File Name: ISH8 18th June 2024 Part 3.mp3
File Length: 01:05:09

Okay. Good afternoon everybody. Now 2:00. Welcome back. Um, and this hearing is resumed. We will start this hearing with item four five on the agenda. Sorry. Which is good design.

Title
Surface Access Highways Plans
Engineering Section Drawings
APFP Regulations 6(2)
Sheet 5 - North Terminal Sections

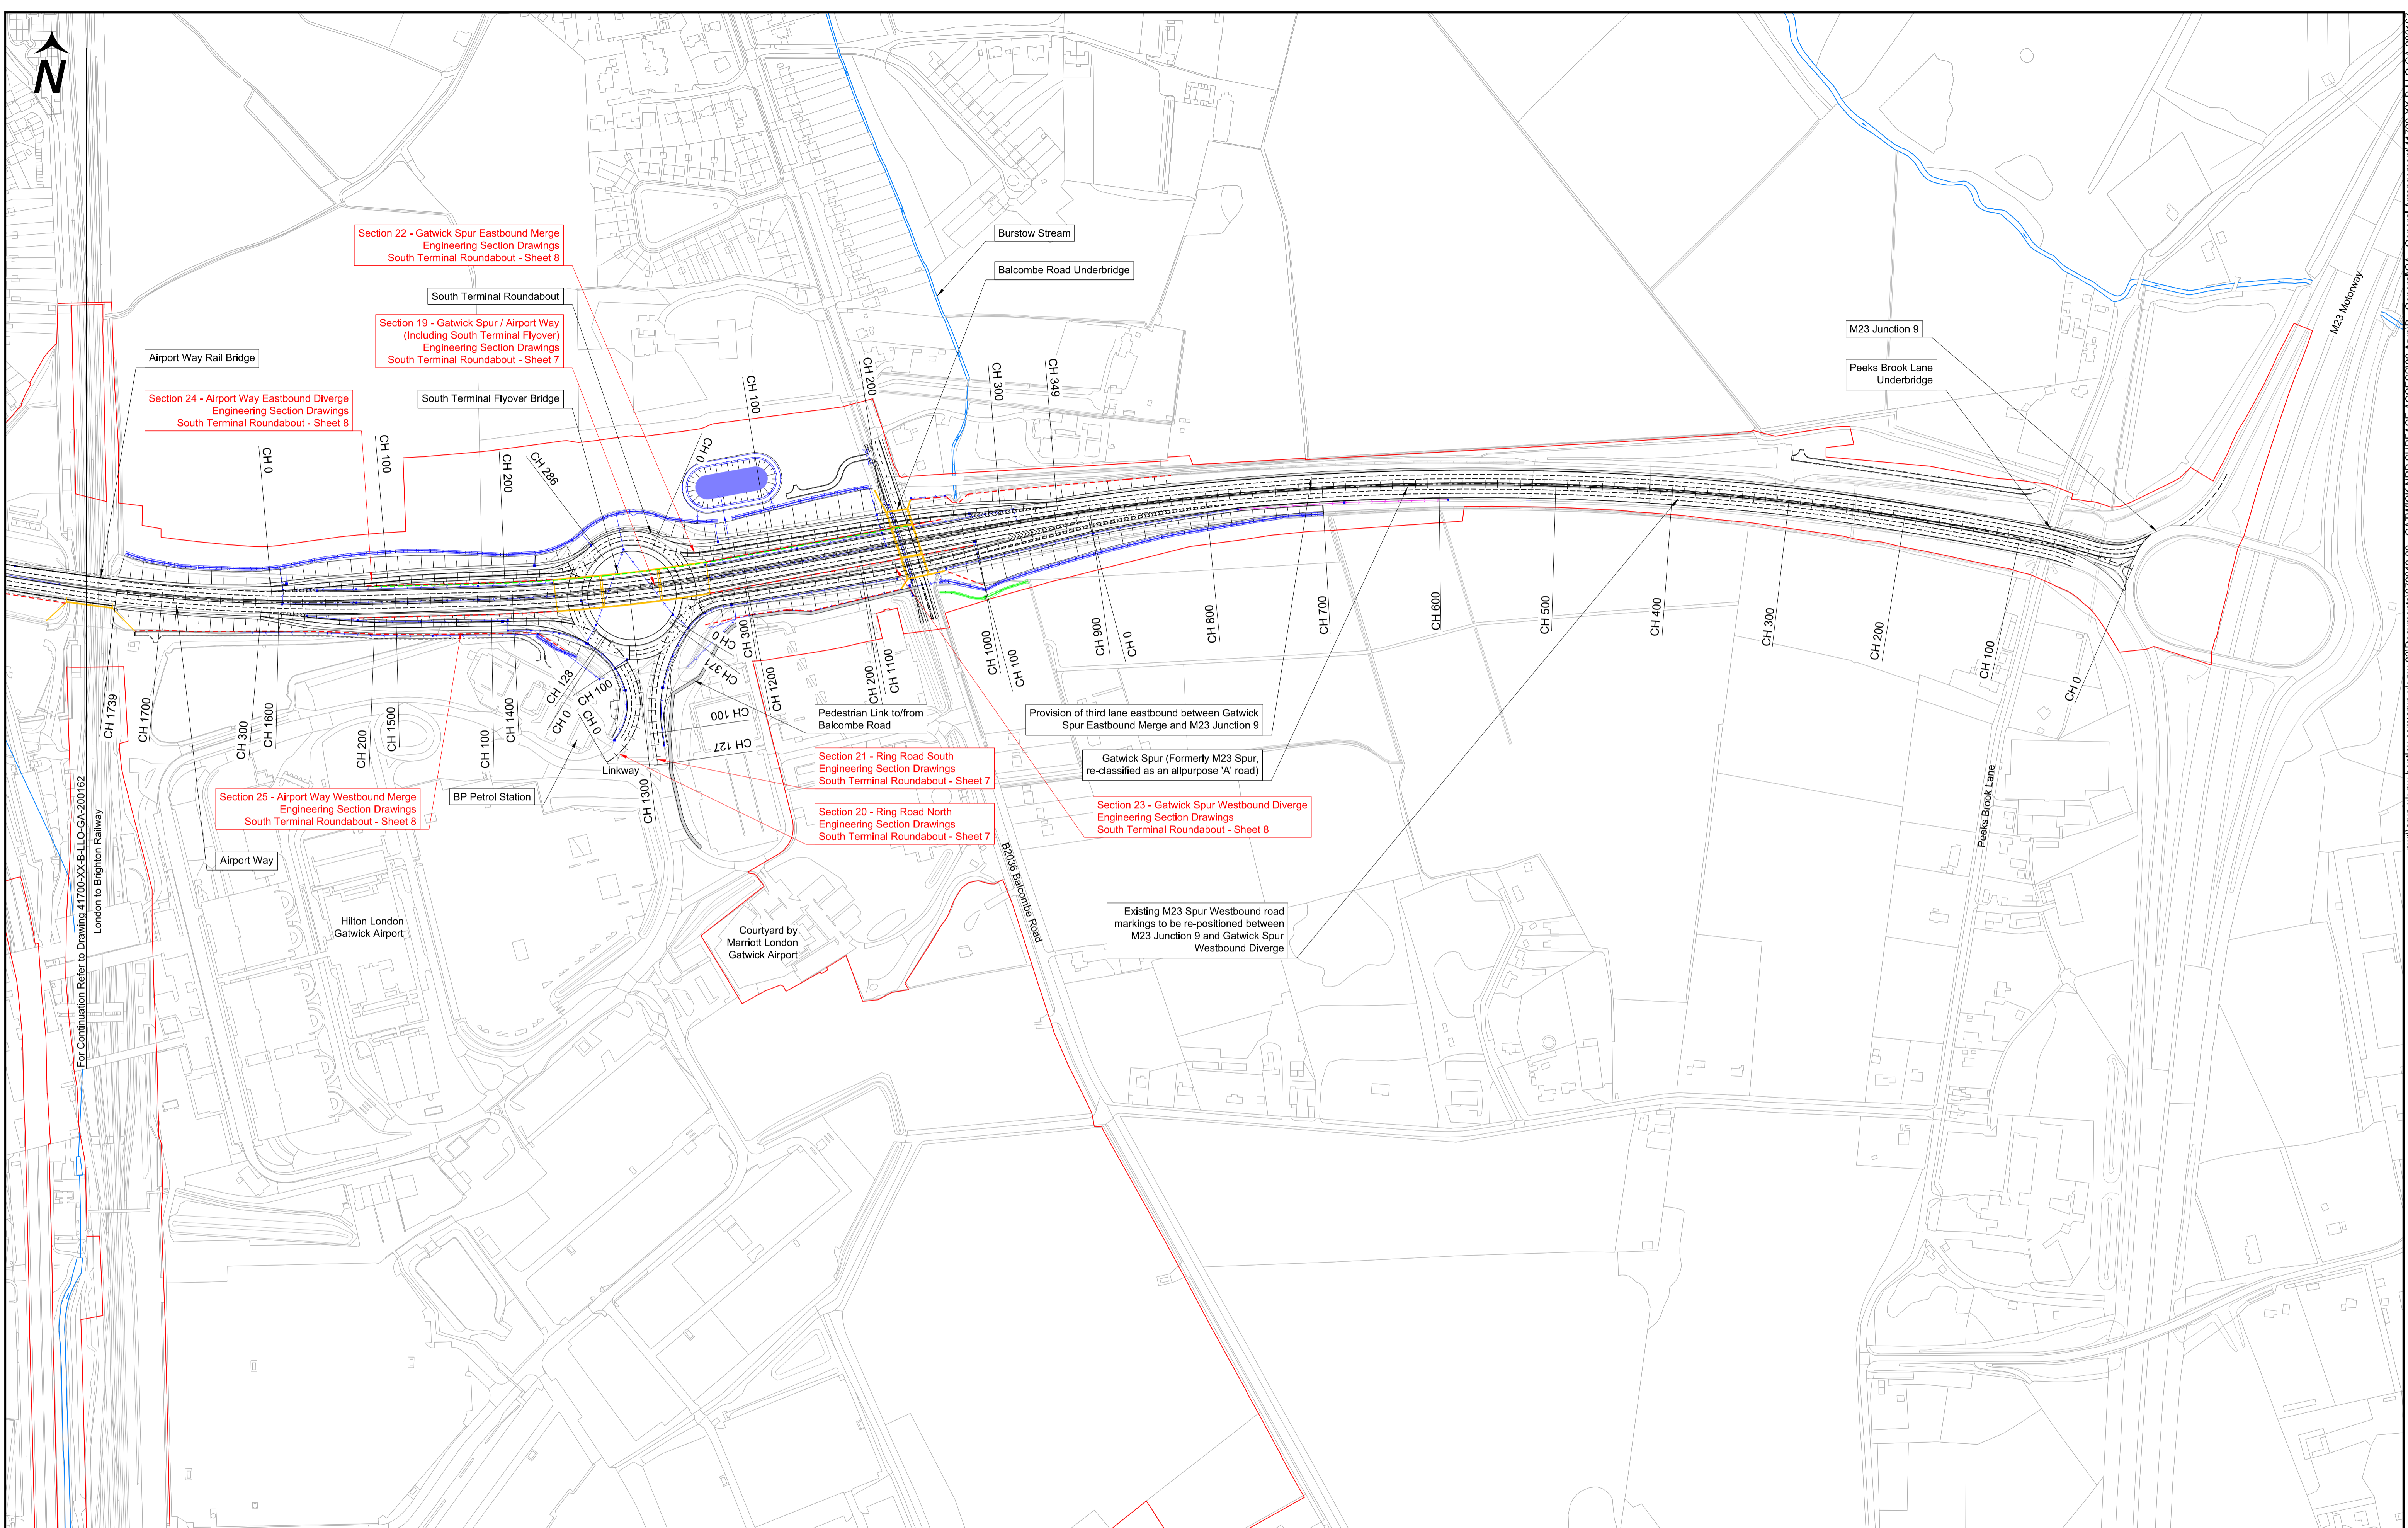
Okay. Thank you. Um, and in the same volume, we've got the surface access corridor. Um, and I note proposals there for new grade separated flyovers at both the north and the south terminals. Um, are there any indicative elevations available of those? I was fairly substantial roadworks.

I see what you mean, but I think there are other proposed elements within the desk where you do have. I understand. Obviously they're indicative, but still indicative elevations. I thought a similar treatment for those two road roadworks could be useful.

Sorry. Darren Atkins for the applicant. So there are indicative elevations for those structures in the structure section. Plans document number rep 3-014 and then the engineering section plans document reference rep 5019. Uh showed the uh vertical alignments of the highways at those locations.

They kind of the applicant. So in the Das we show indicative 3D views of the highways works and and layout plans of the highways works which give an overview of of those works. I mean, the Das we've tried to keep the level of information for each of the works to the same level, so the reader can understand the development at the same pace. The highways works and some of the landscape works are more detailed in their design development, particularly the highways works because the stage it needs to be at. So we've tried to present all the information of each of the works to a similar level of design development, so it's read consistently by the reader.

Scotland for the applicant. I mean, if it's a case of perhaps signposting within the Dass where this other information that's been referred to can be found. And take that away. Sir, if you'd find that helpful.
